Hunsworth Lane, East Bierley,
BD4 6PU

Combined Stage 1-2 Road Safety Audit Response Report

CLIENT: East Bierley Community Sports Association Ltd
PROJECT TITLE: Hunsworth Lane, East Bierley,
 BD4 6PU
REPORT TITLE: Combined Stage 1-2 Road Safety Audit Response Report
PROJECT REFERENCE: 152698
DOCUMENT NUMBER: 004
ISSUE NUMBER: 01
DATE: March 2025

Drawing Number	Rev
152698-C8-1100	B

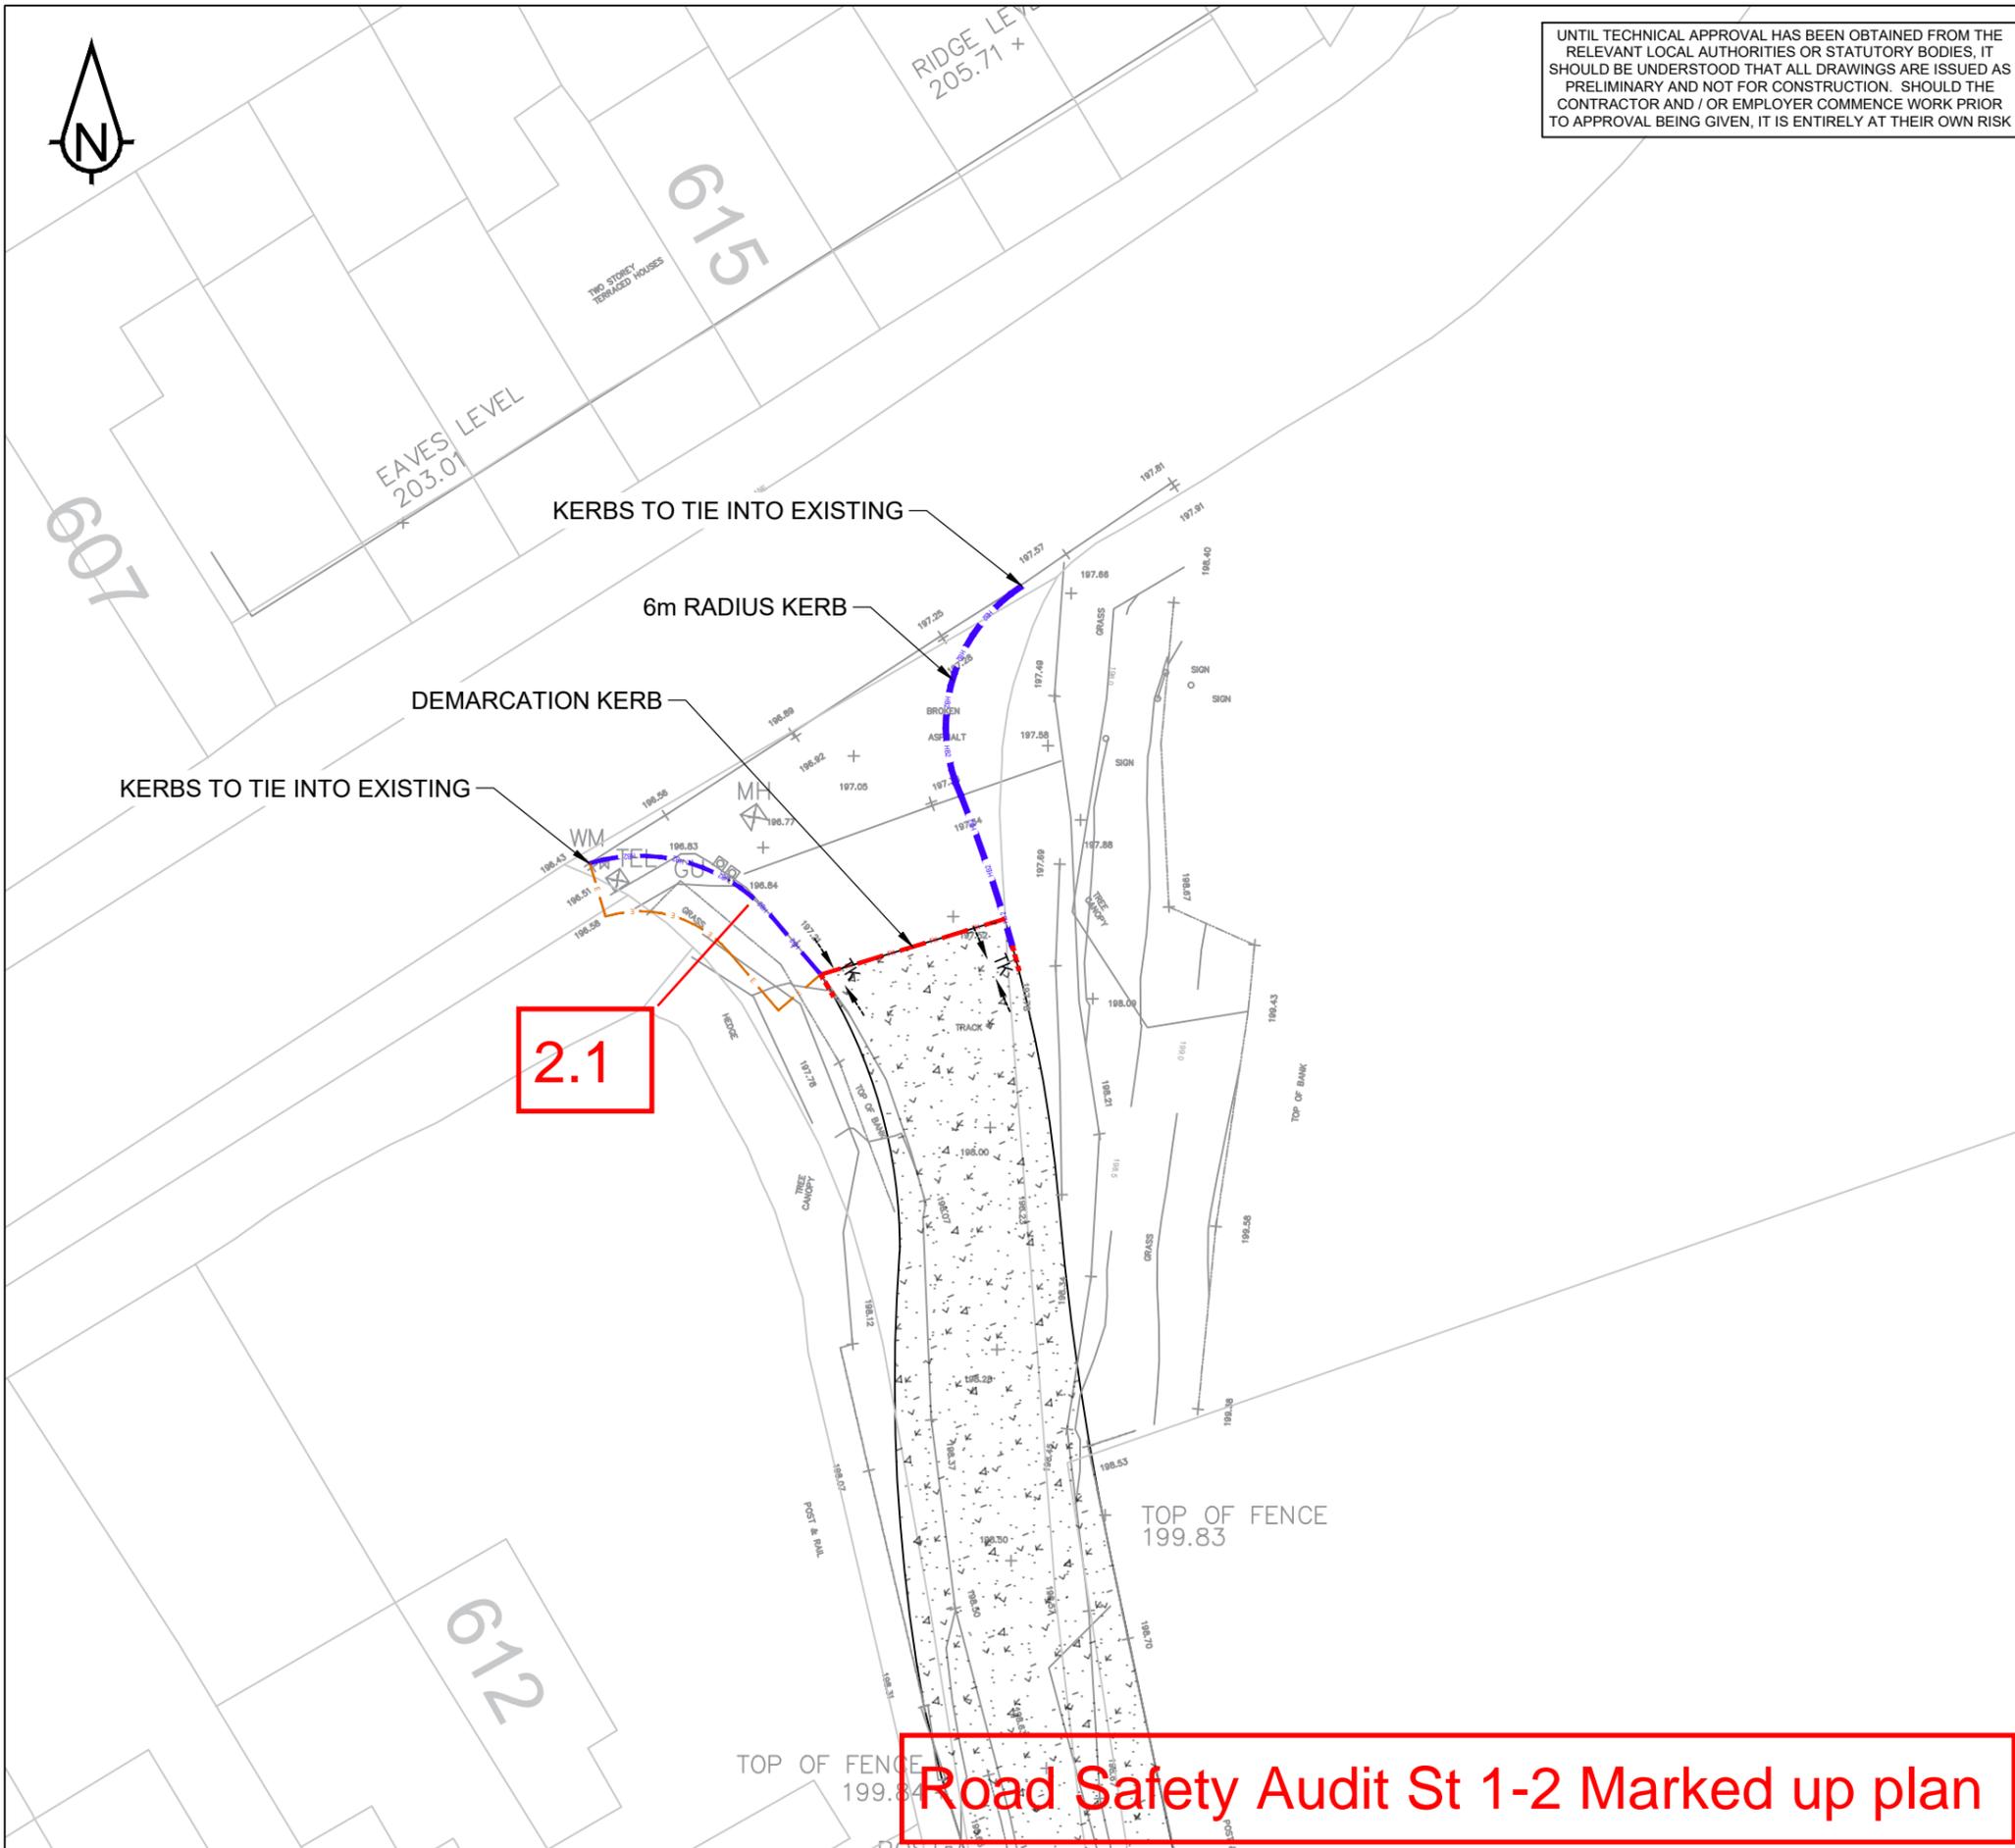
RSA Problem	RSA Recommendation	Design Organisation Response	Overseeing Organisation Response	Agreed RSA Action
<p>Problem 2.1: Location: west side of access junction.</p> <p>Summary: There is an existing footway that runs along Hunsworth Lane to the west and at the moment pedestrians can join the existing surfaced crossover without crossing a kerb. New full height kerbs are proposed on the western radius together with a short section of footway but there is no detail to show how a pedestrian would join the surfaced access crossover. Full height kerbs present a barrier to mobility impaired pedestrians such as wheelchair users which could result in them being struck by passing vehicles if they are forced to enter the carriageway at inappropriate locations. Full height kerbs will also increase the risk of trips and falls by able bodied pedestrians as they cross on to the access, noting that the footway does not continue along Hunsworth Lane to the east.</p>	<p>Provide a dropped kerb crossing point in an appropriate location on the surfaced section of the access crossover.</p>	<p>The designers acknowledge the problem and recommendation.</p> <p>The designers propose to discuss the recommendation with the Overseeing Organisation and implement the agreed action / non-action.</p>
